Your ref: 3/2016/0124
Our ref: DC/16/593
Date: 22-FEB-16

Location: Land off Chatburn Old Rd, Chatburn

Proposal: discharge of condition 6 - foul and surface water drainage

Drawing No. **2015/08/B** Drawn by *T. Henson*

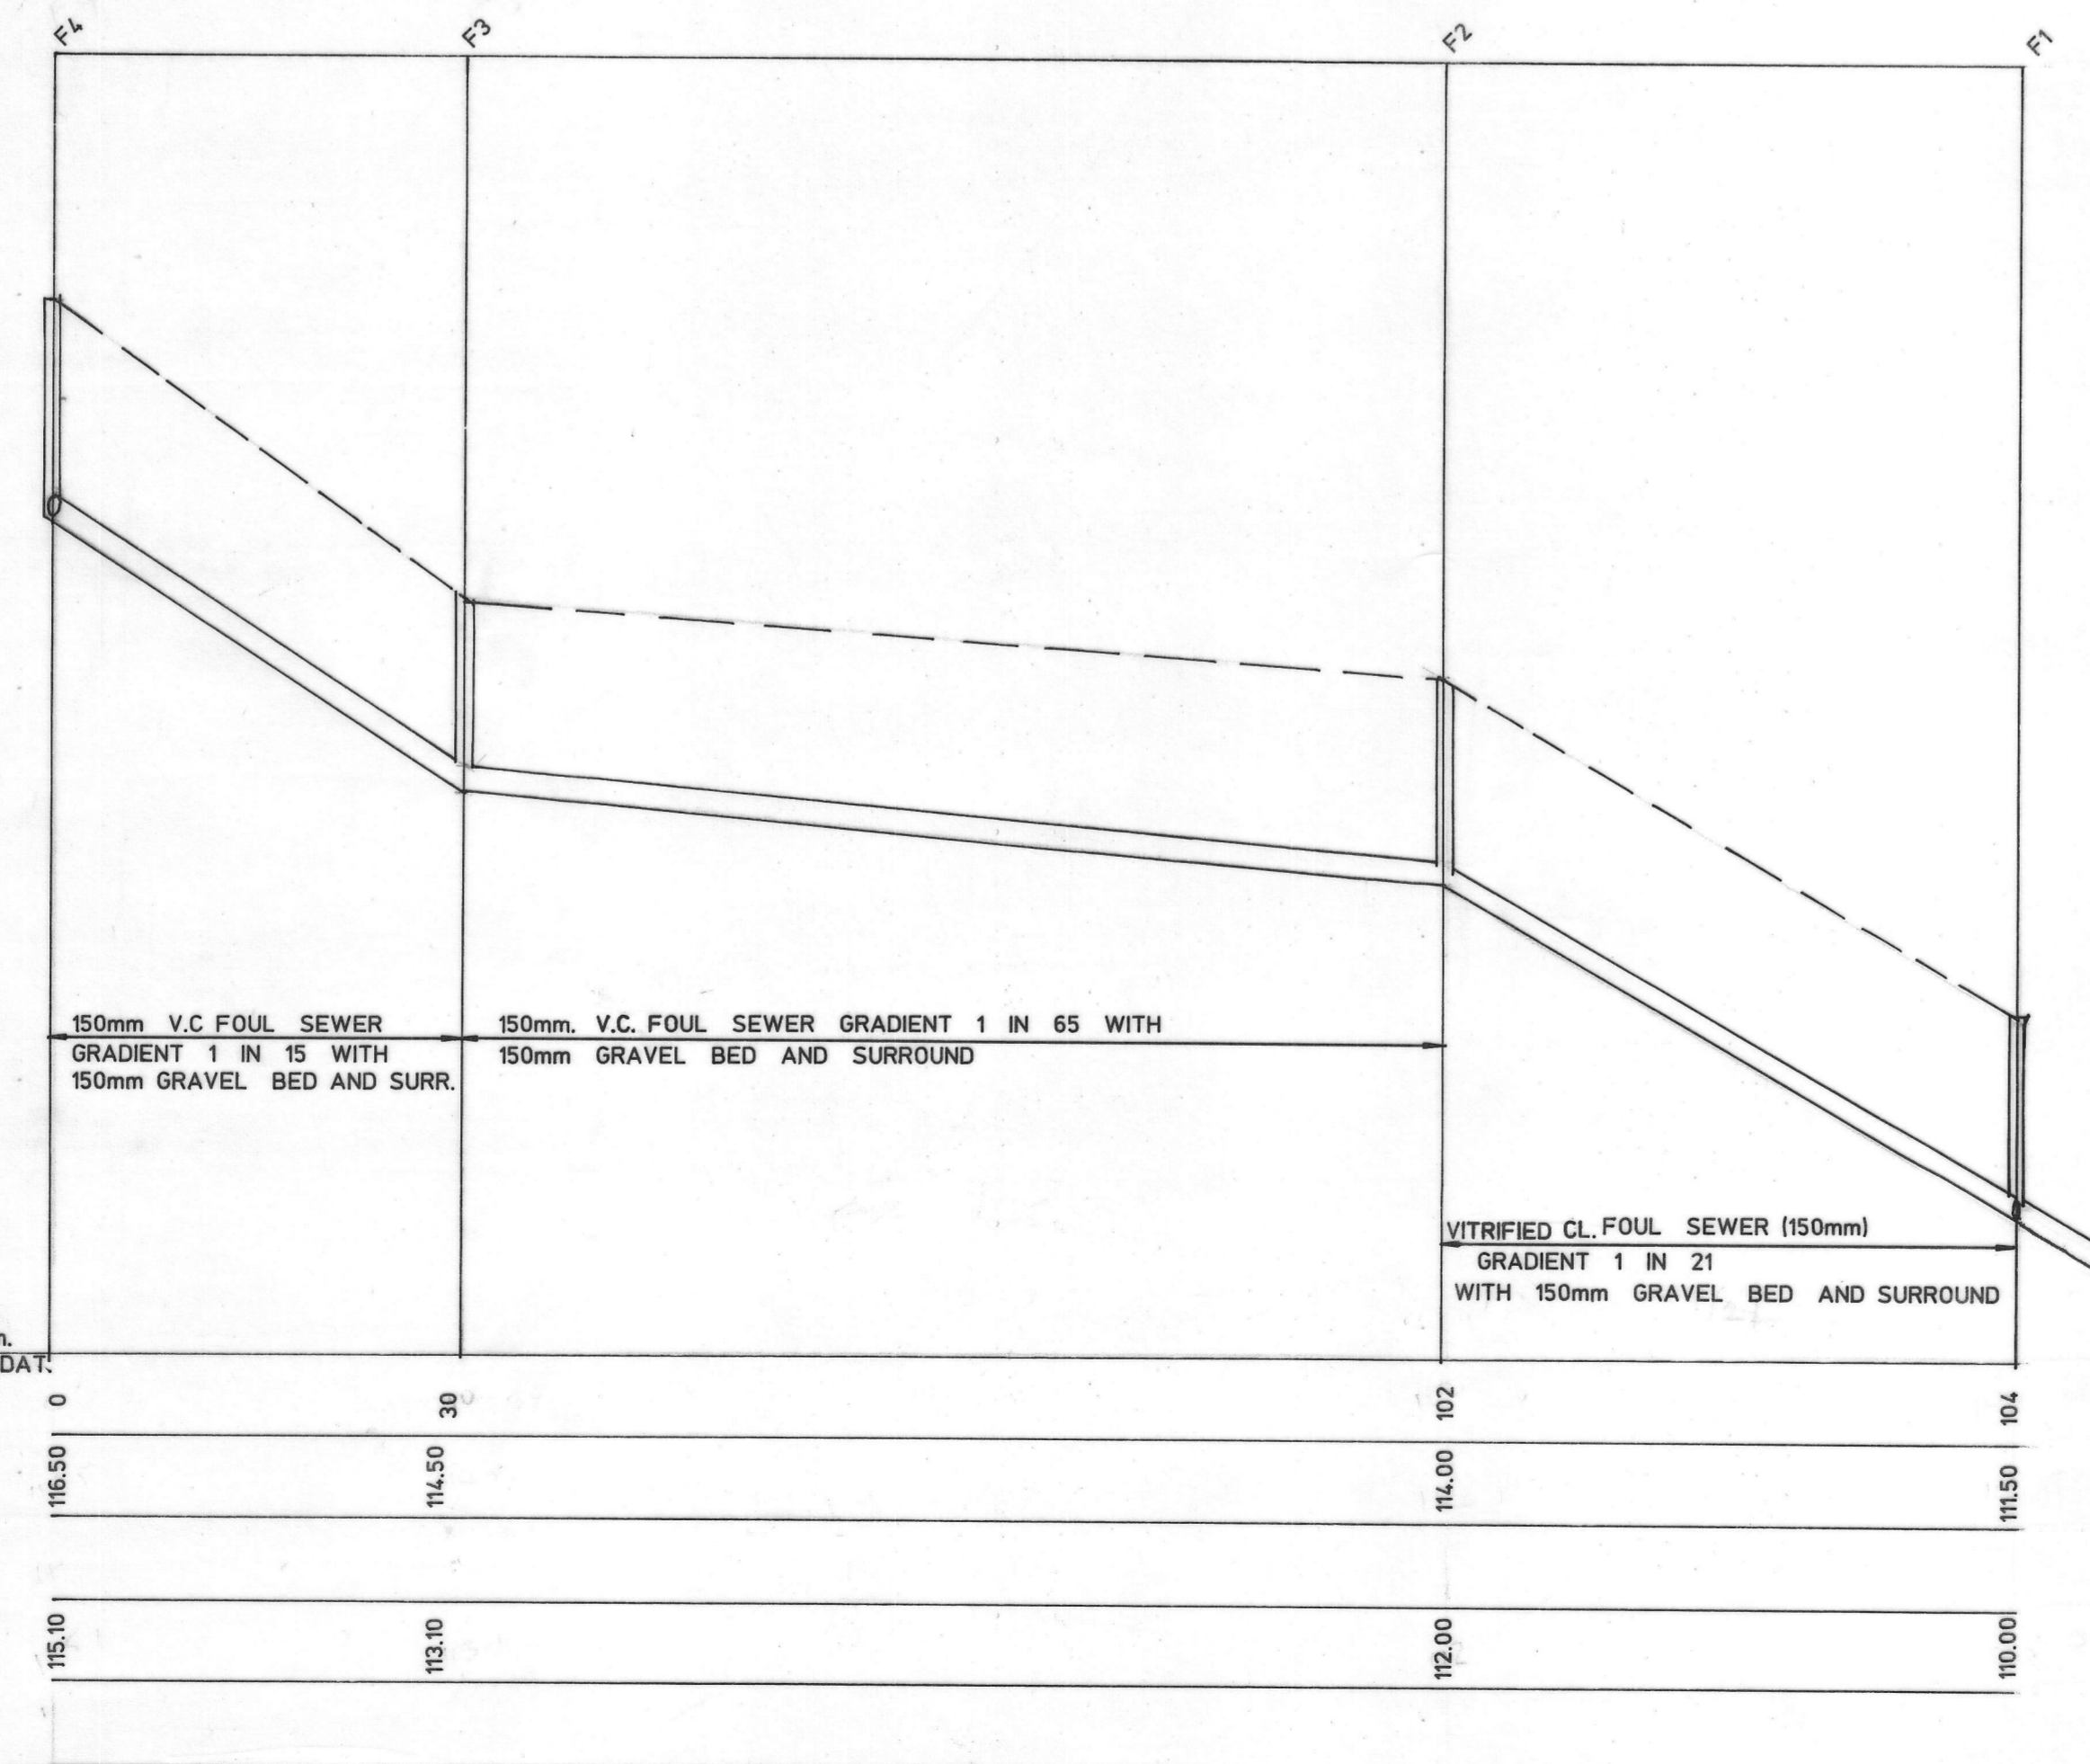
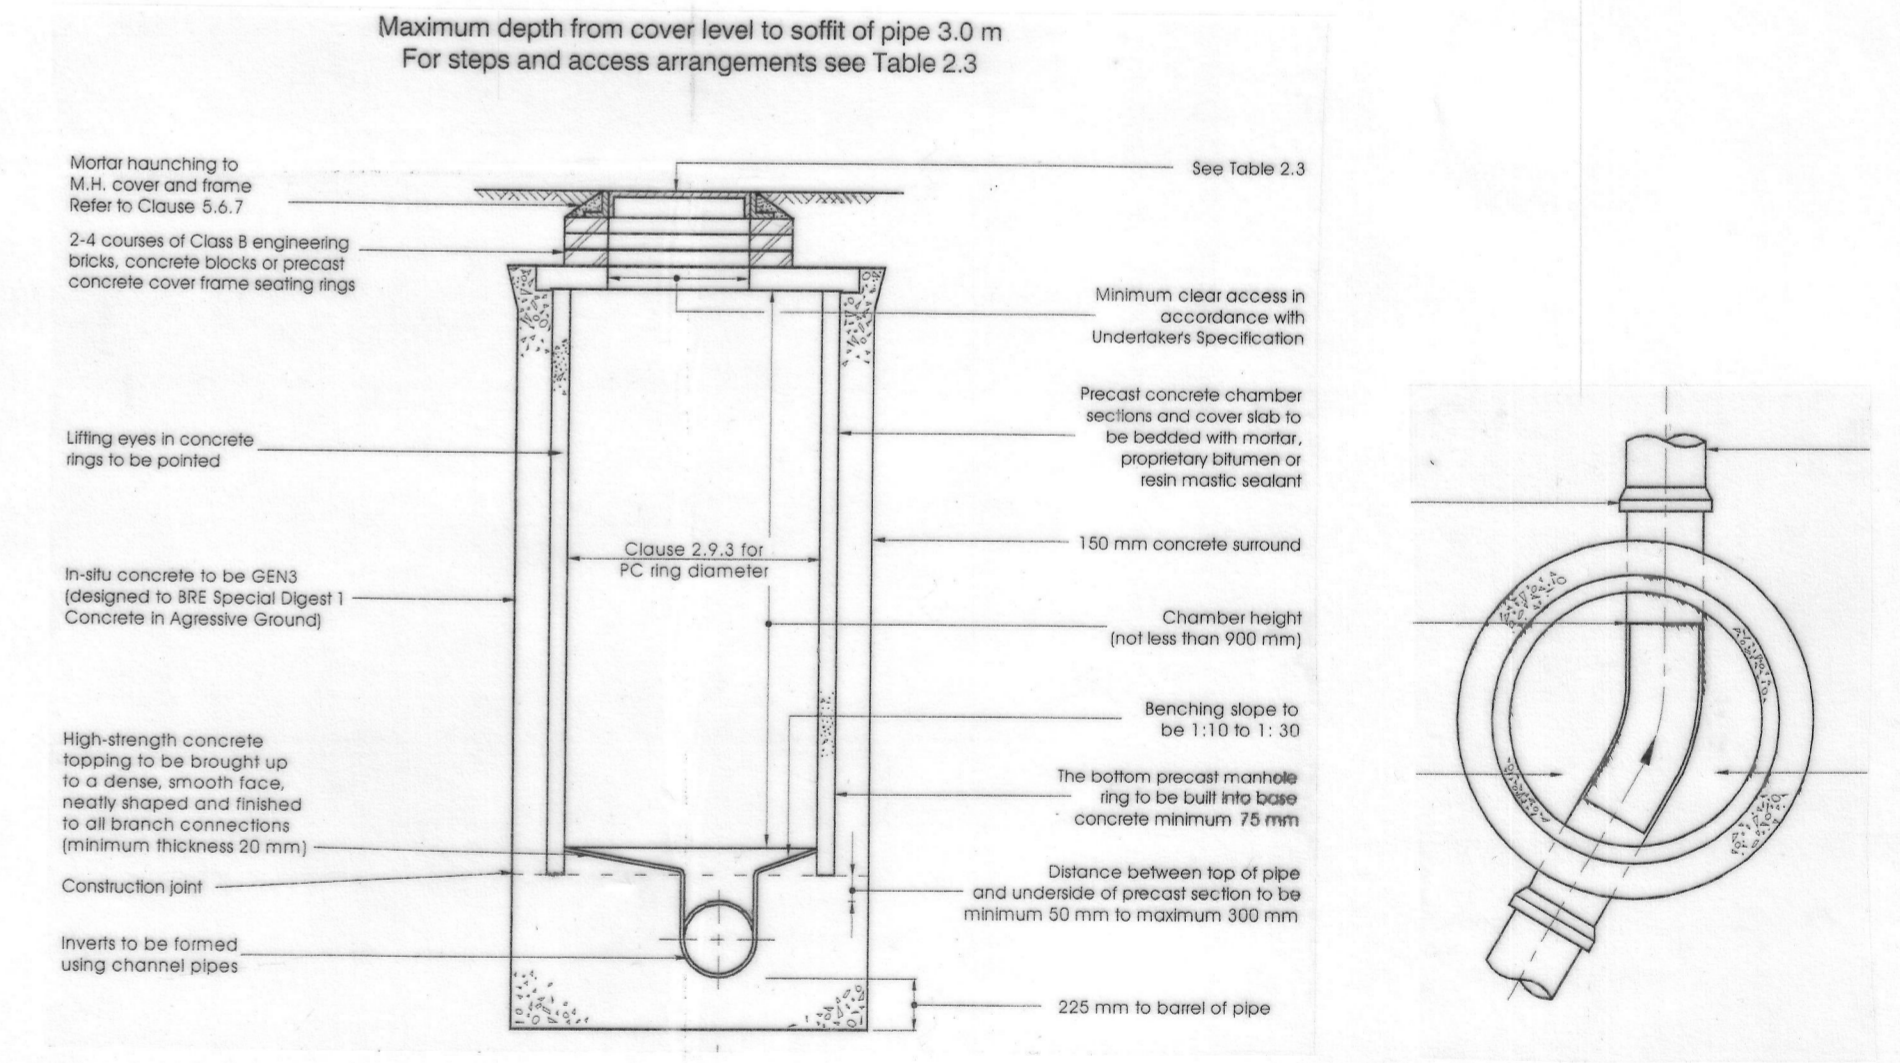
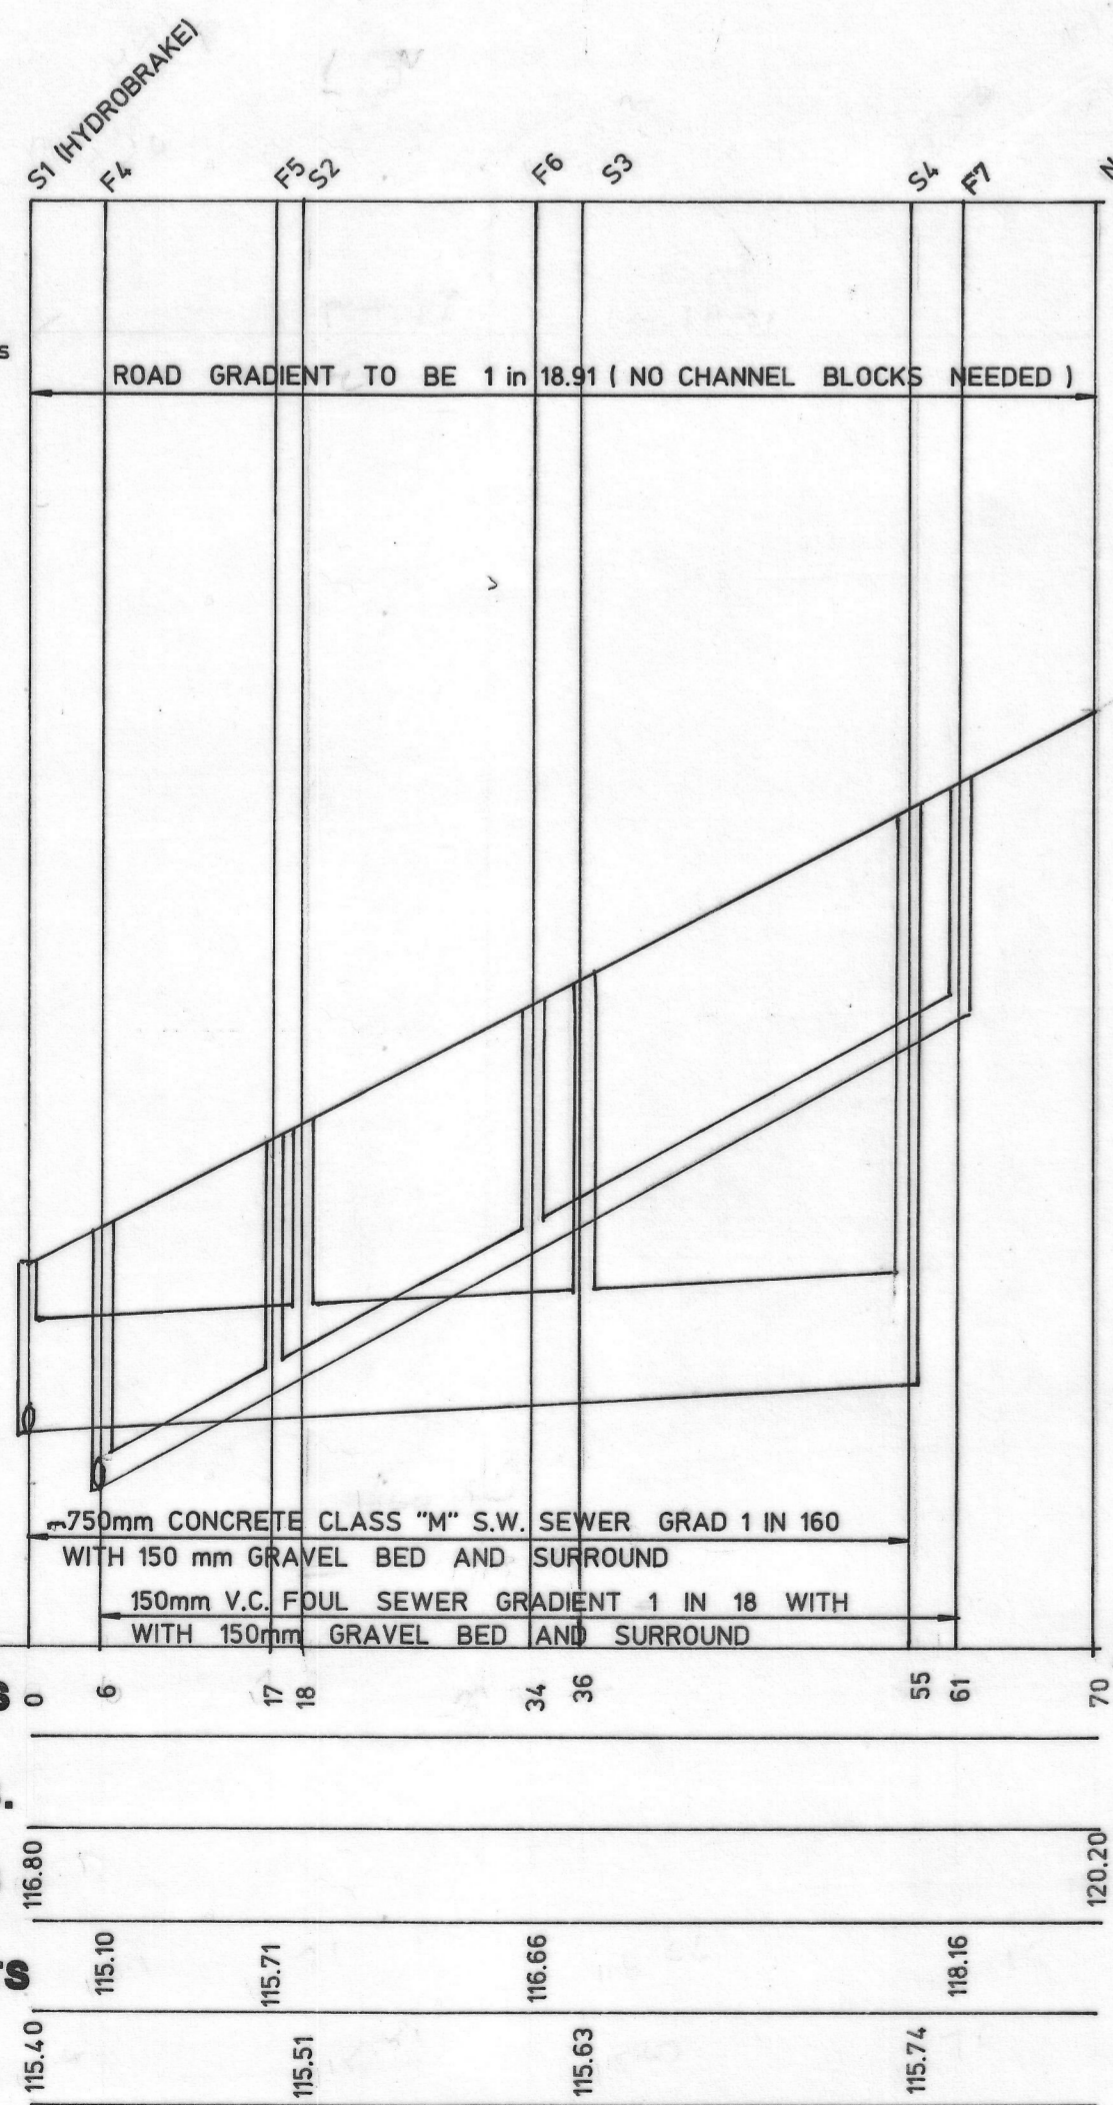
With reference to the above application, United Utilities are unable to discharge conditions relating to drainage. It is unclear where the developer intends to drain the public high way.
